Subject: 27 Central Drive, Middleton - M/91/21/PL

I have passed your email of representation onto Mrs Gardner who is the officer dealing with the new application M/91/21/PL.

PROJECT	27 Central Drive - Elmer Beach	DATE	16/09/18
TITLE	Proposed South Elevation	DRG NO	IBA/507/05
SCALE	1 : 50	REVISIONS	B

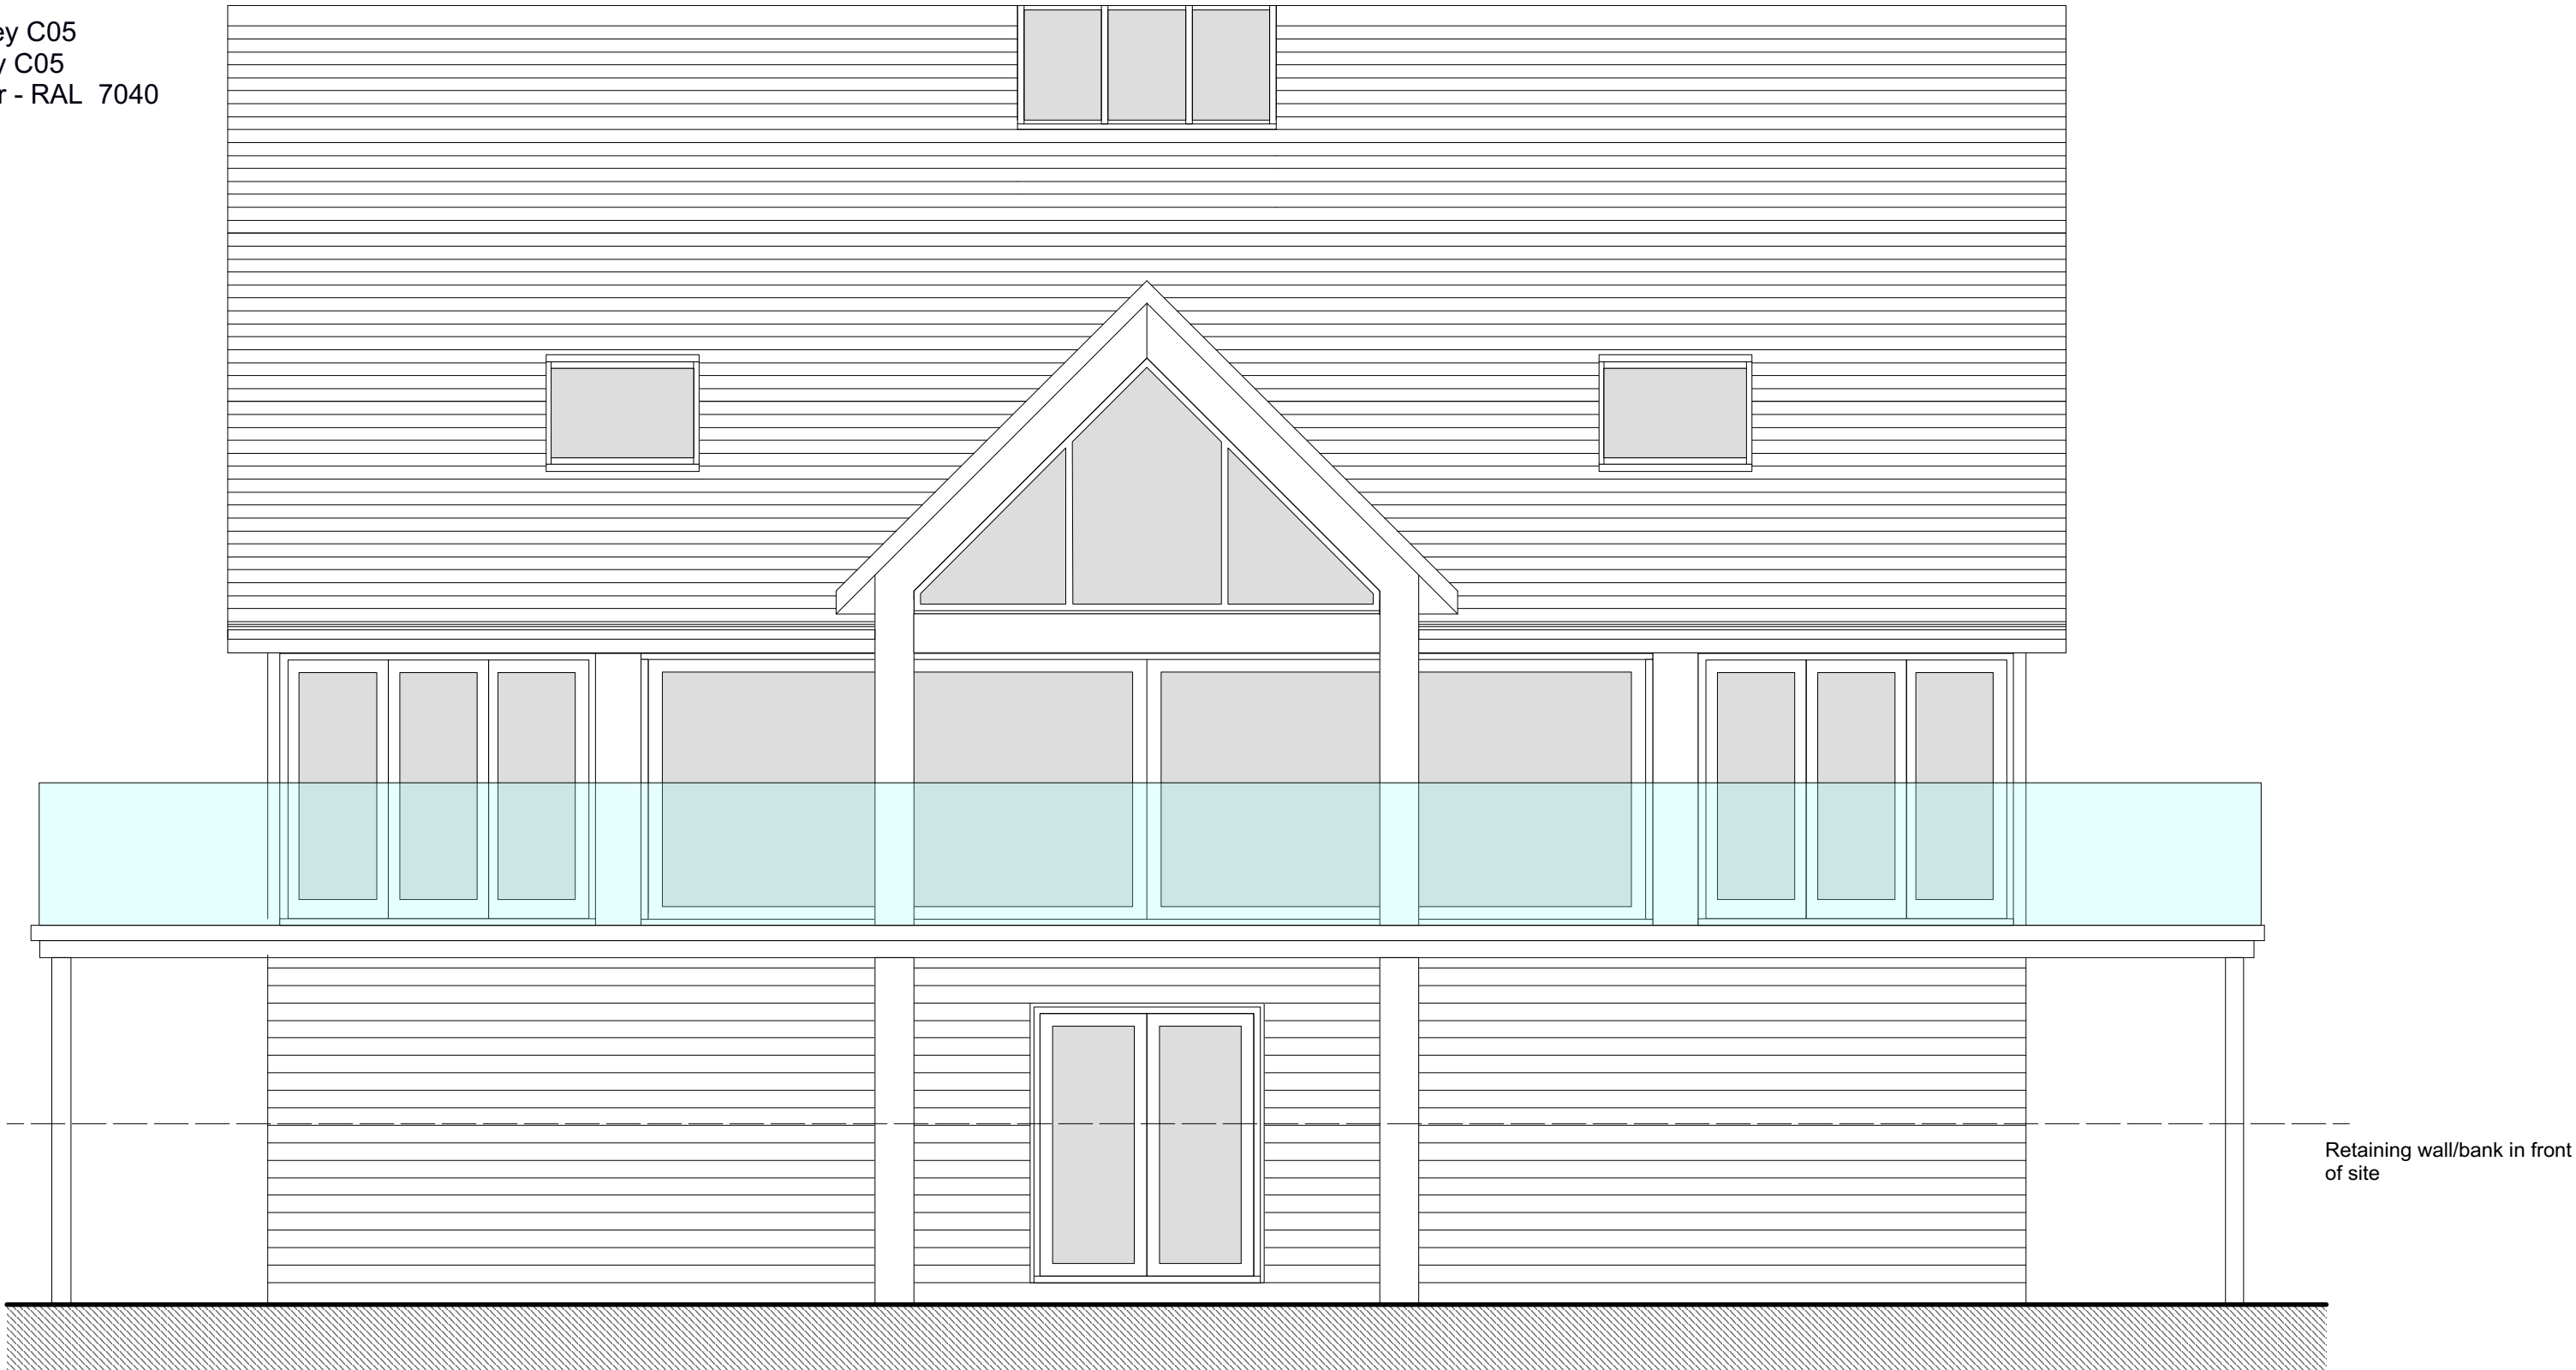
The excessive height of the building is above the originally approved elevation plan ,

It will obscure the view from my property

The appearance from the beach side where the property towers above neighbouring properties is out of keeping .
